**KIRKLEES METROPOLITAN COUNCIL
INVESTMENT & REGENERATION SERVICE**

**DELEGATED DECISION TO DETERMINE APPLICATIONS FOR
CONSENT, AGREEMENT OR APPROVAL REQUIRED BY CONDITION**

Reference No:	2025/44/90459/W
Site Address:	Private Car Park, Sheepridge Road, Sheepridge, Huddersfield, HD2 1HG
Description:	Discharge of details reserved by condition 4 (drainage) of previous permission 2022/90464 for use of land for car wash and access works to create one-way system
Recommending Officer:	Kerri Simpson

DECISION – Discharge of Condition - Refused

DRAWING STATUS:		A - FIT FOR CONSTRUCTION	
kita. ENGINEERING			
SITE/PROJECT:			
SHEEPRIDGE ROAD			
TITLE:			
STANDARD DETAILS SHEET 2 OF 2			
SCALE @ AT:	DESIGNED:	DRAWN:	DATE:
As Shown	OK	OK	January 2025
DRAWING No:			REV:
SHRP-00-CV-SD-0101			C01

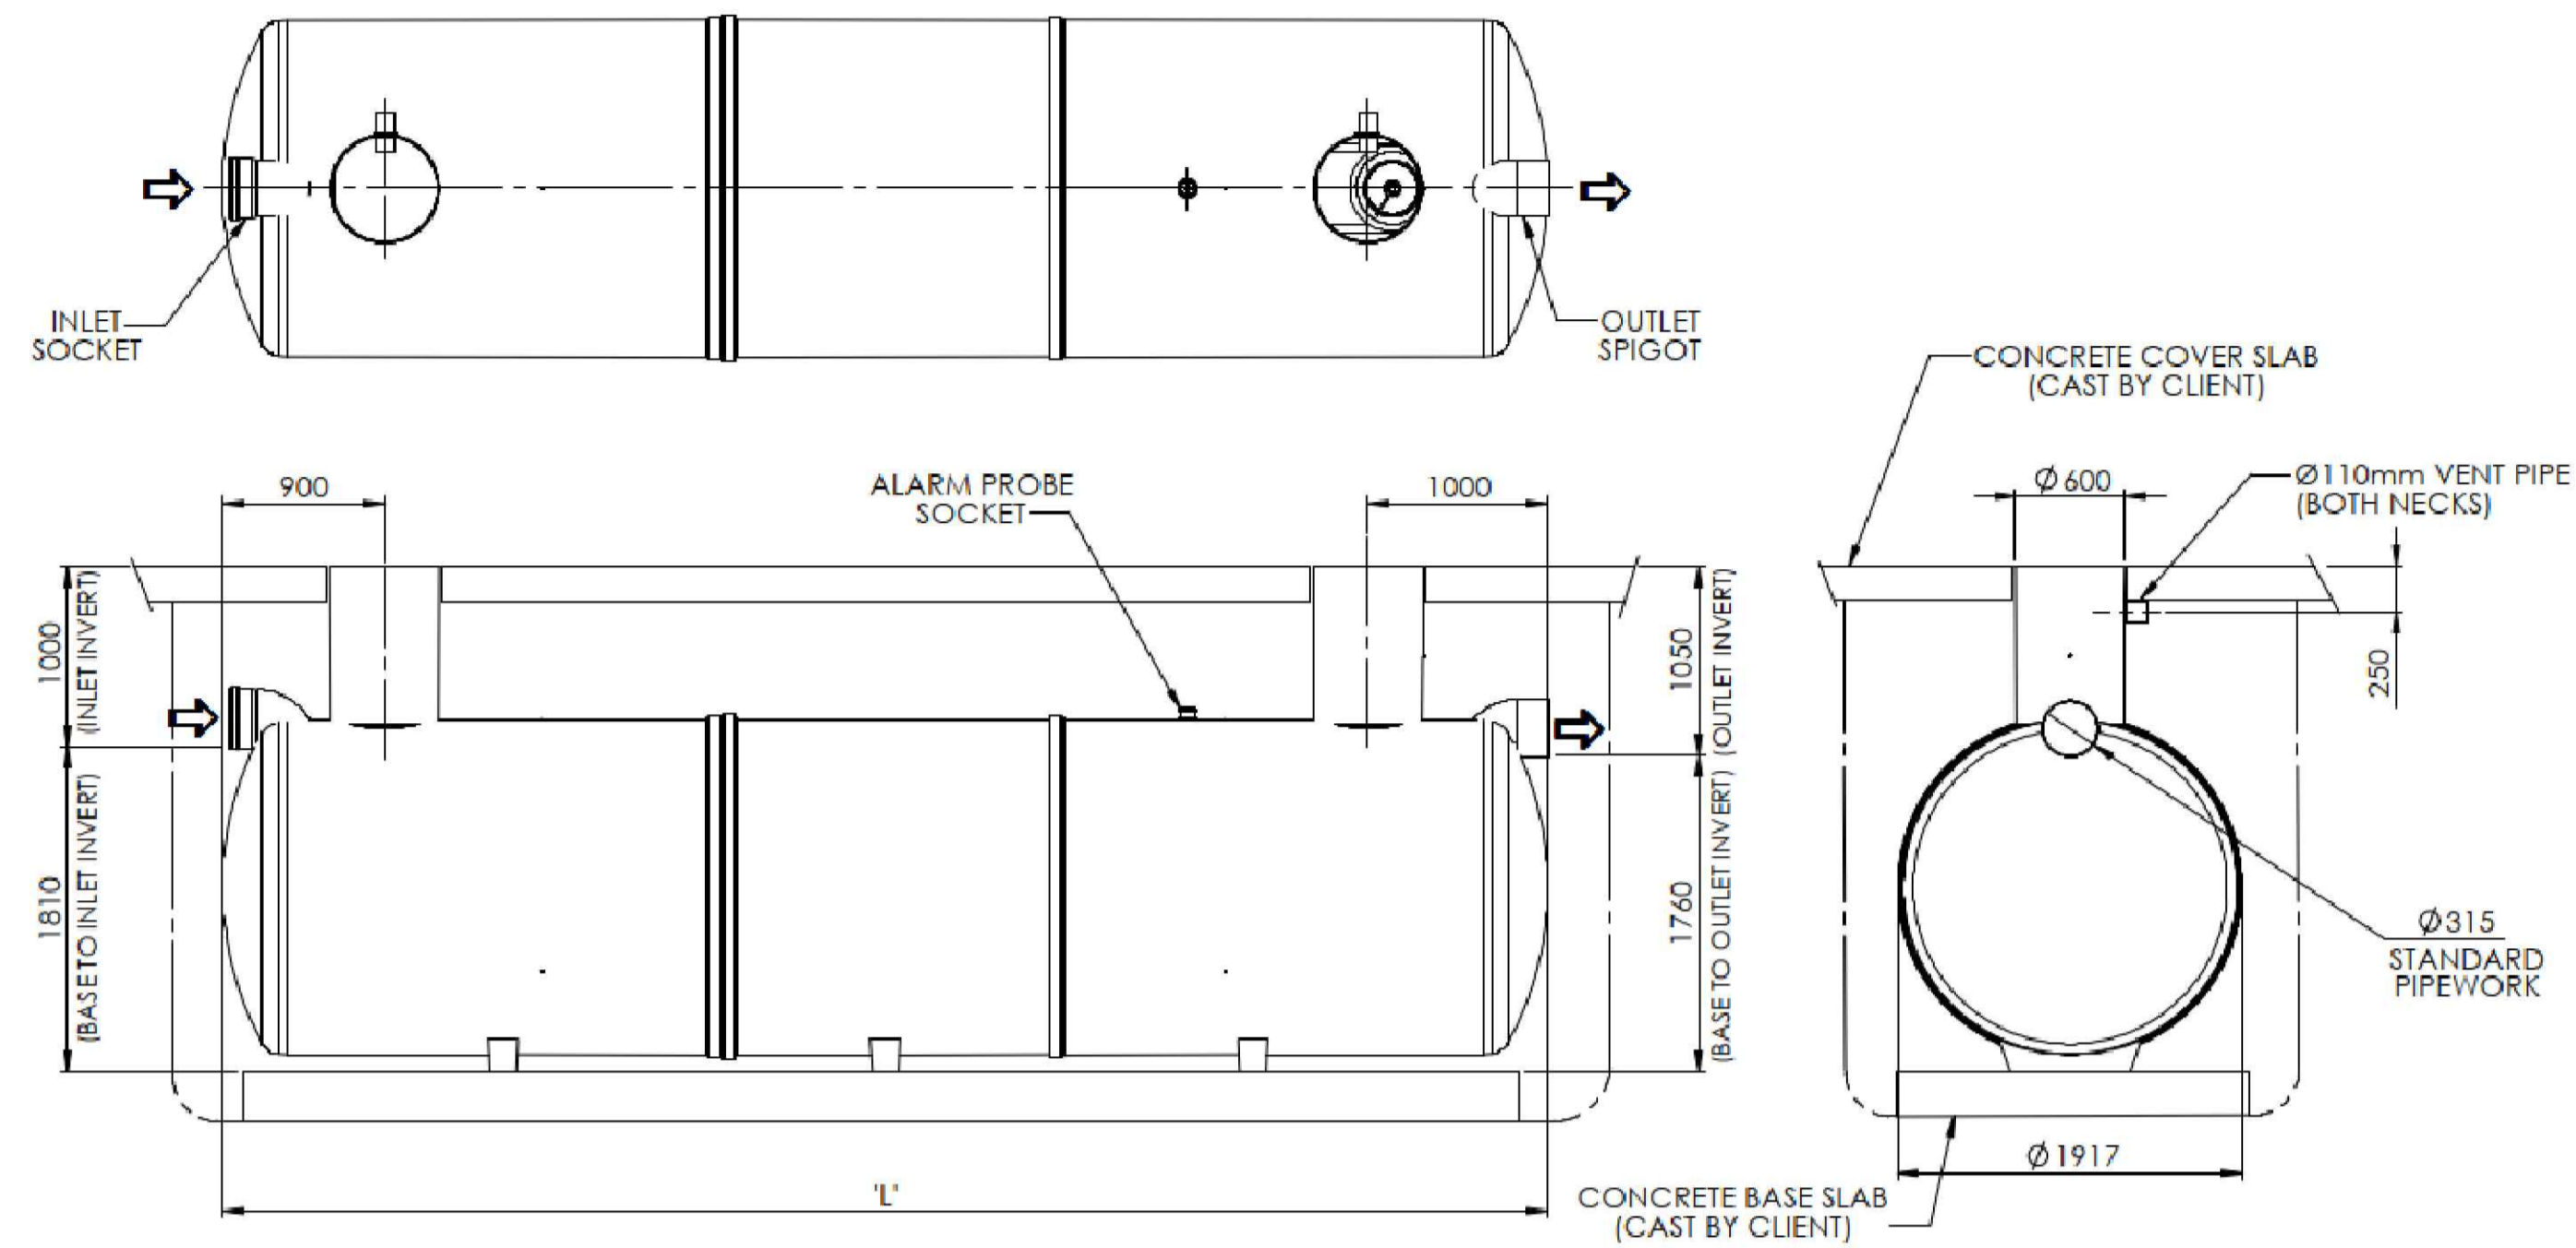
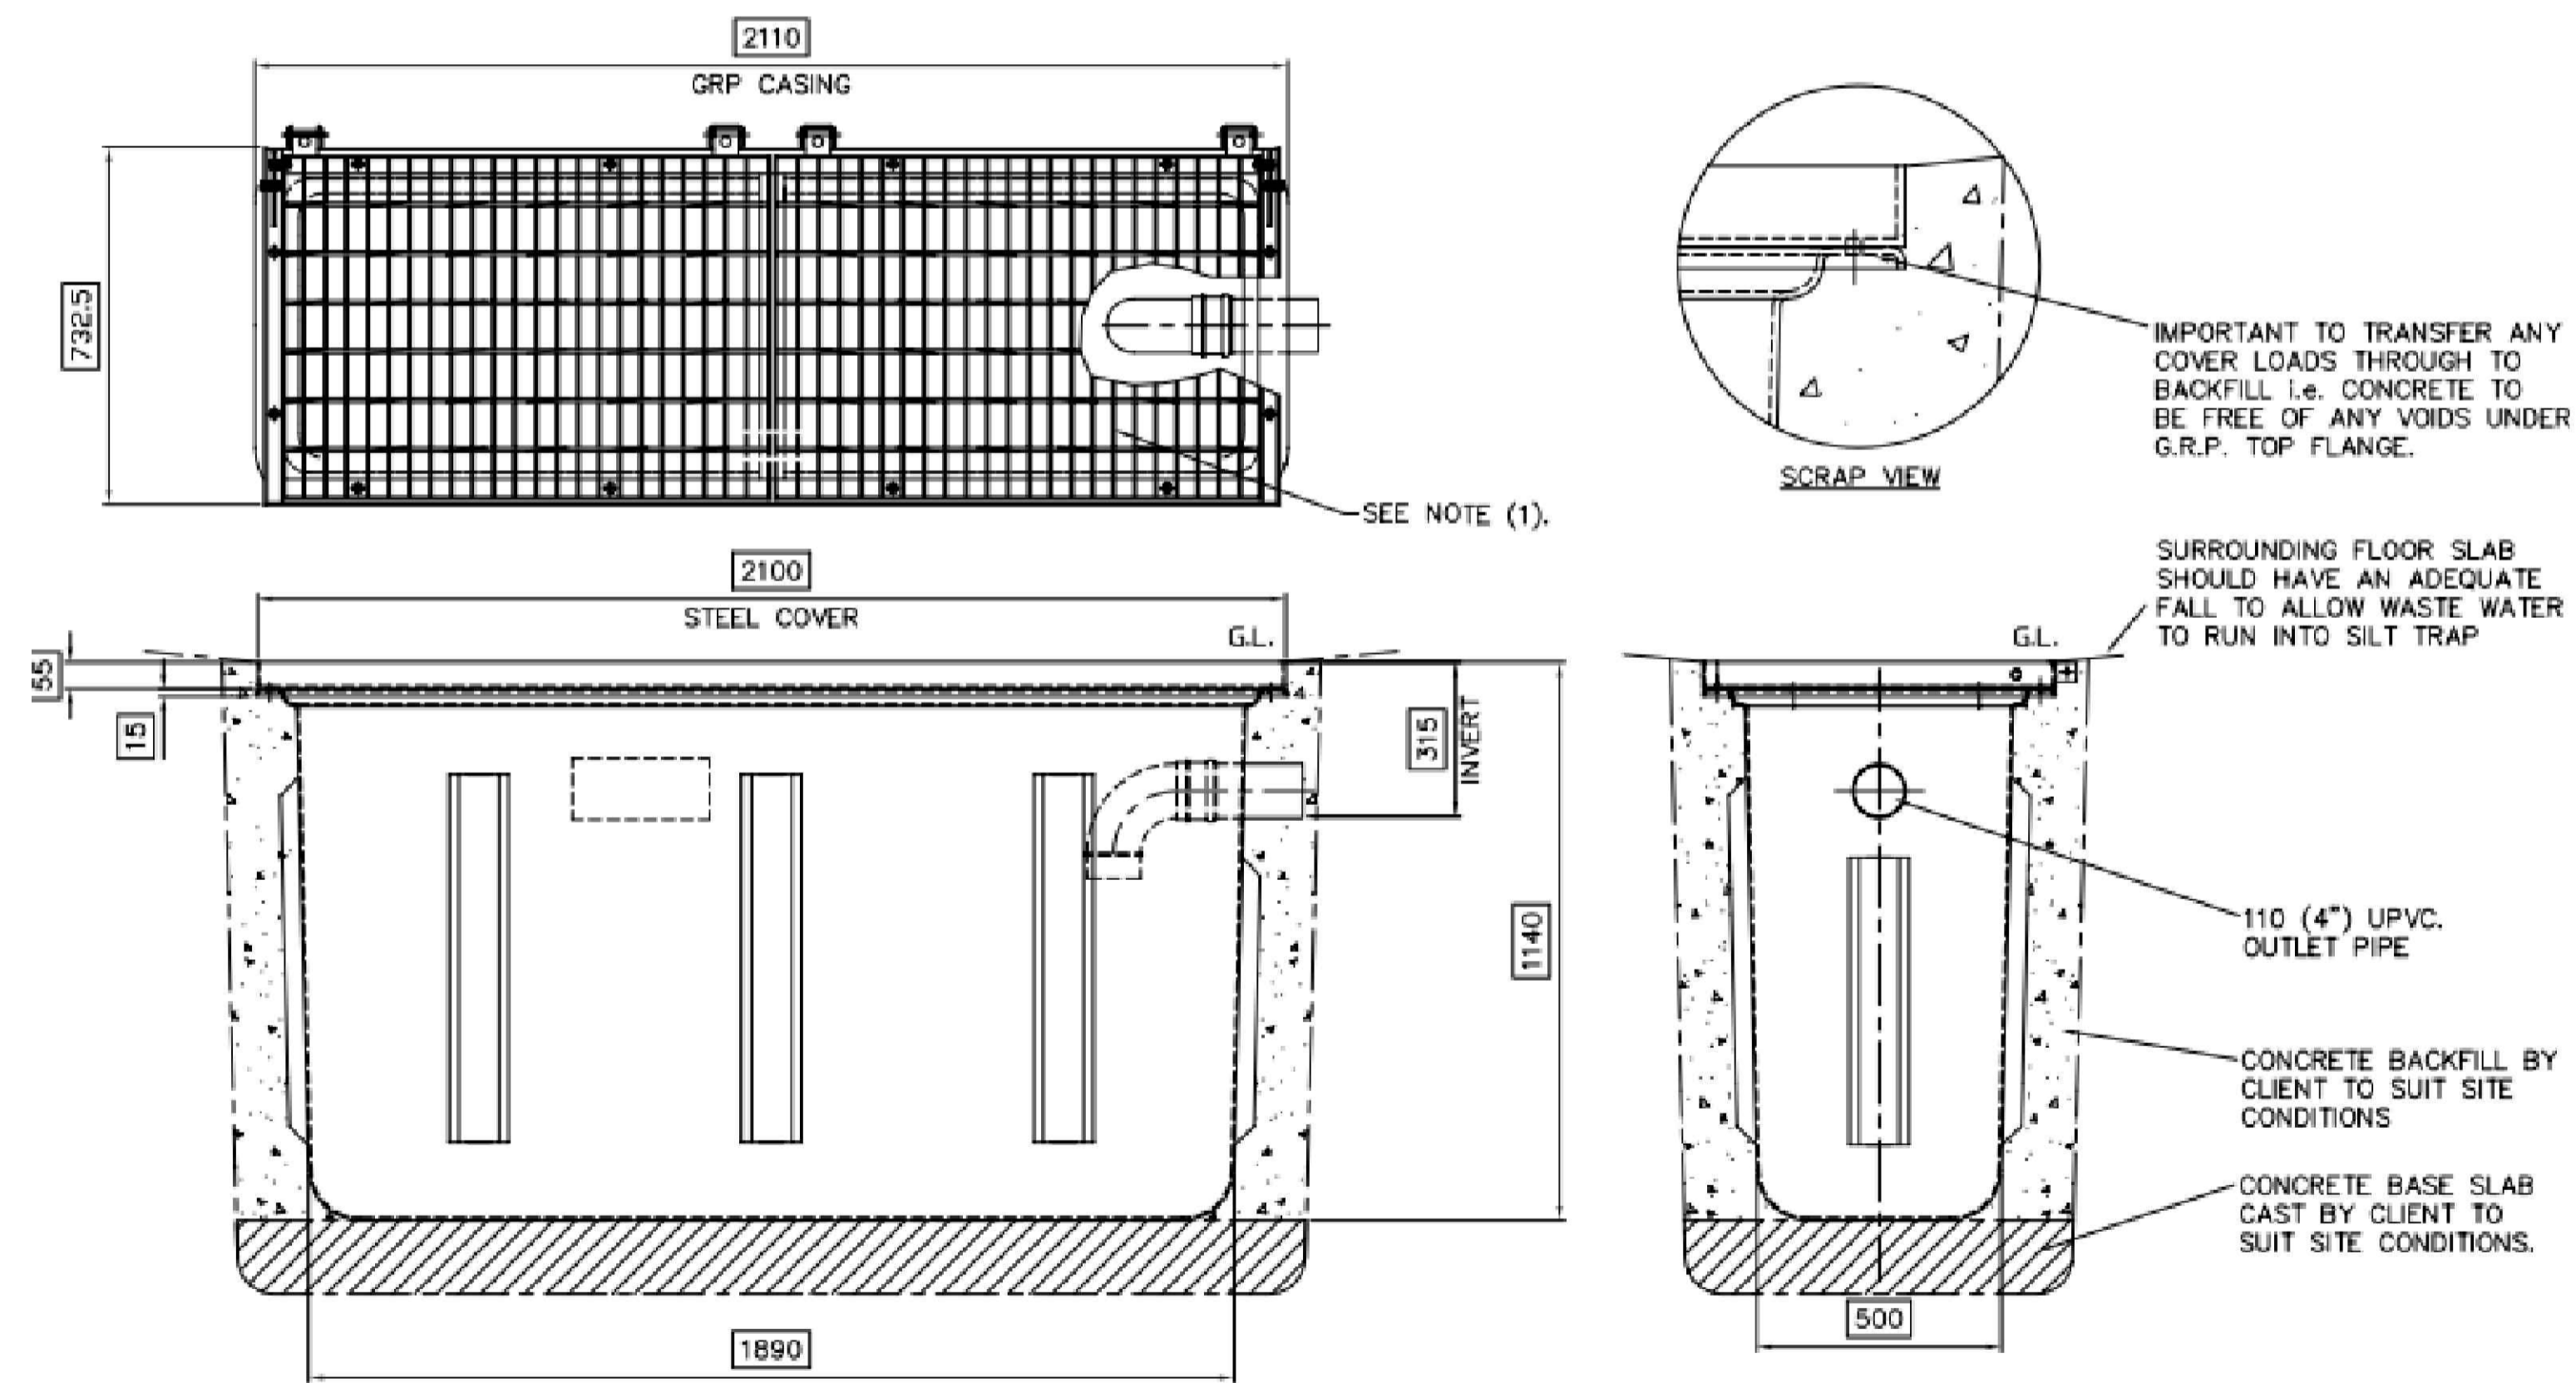
Furthermore, the drainage strategy does not adequately demonstrate compliance with Yorkshire Water’s requirements in respect of surface water management. Surface water from vehicular areas must be routed through an

appropriately designed oil, petrol and grit interceptor prior to discharge. In addition, surface water from high-risk areas (including fuel delivery areas, forecourts, and vehicle washing areas) must not discharge to the surface water sewer network and must instead be directed via an interceptor to the foul or combined sewer. The current submission also fails to confirm that interceptors are located upstream of any on-site attenuation or storage features, as required by good drainage practice.

TITLE: OVERALL SITE LAYOUT AND CONTOUR PLAN

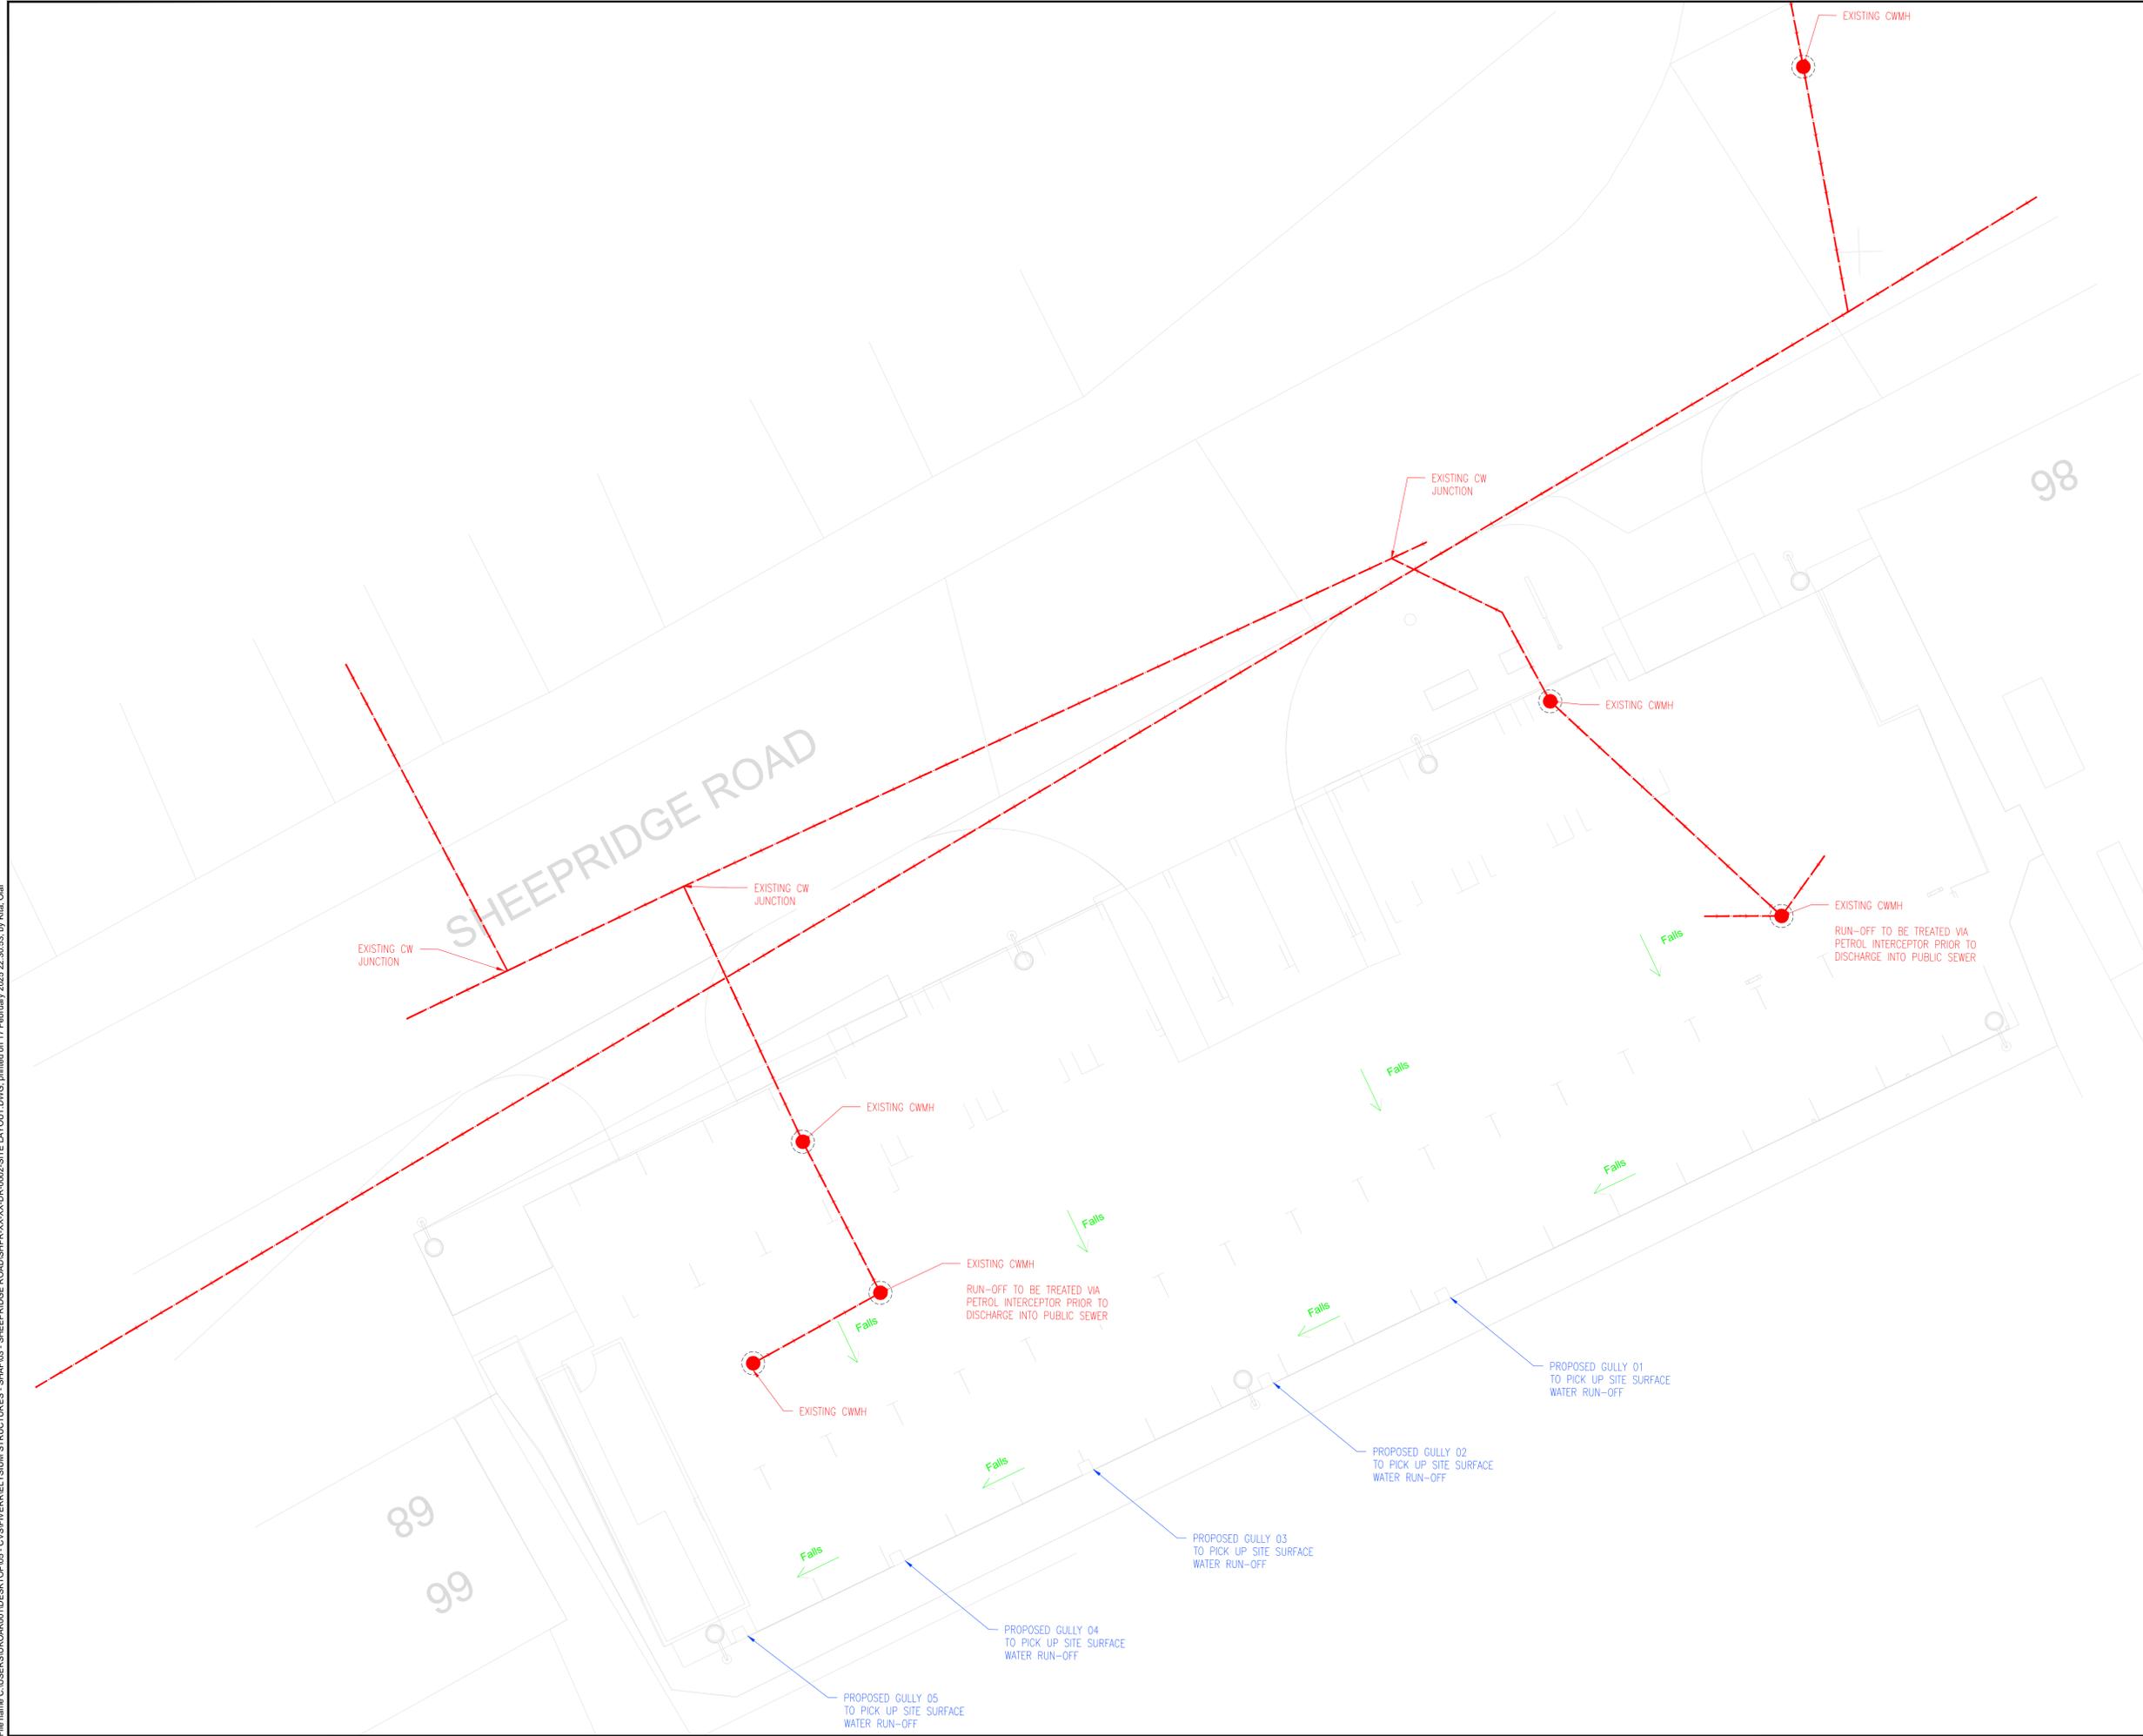
Yorkshire Water have reviewed the submitted drainage details (Drawing No. SHRP-00-CV-DR-00 Rev. C01, January 2025) and confirmed that the information provided is insufficient to demonstrate an acceptable drainage strategy.

In particular, the submitted drawing does not clearly illustrate the relationship between the existing drainage and proposed gullies, nor does it show how flows will be conveyed through the system or how contaminated run-off (including cleaning water) will be treated prior to discharge. A comprehensive proposed drainage layout is therefore required.
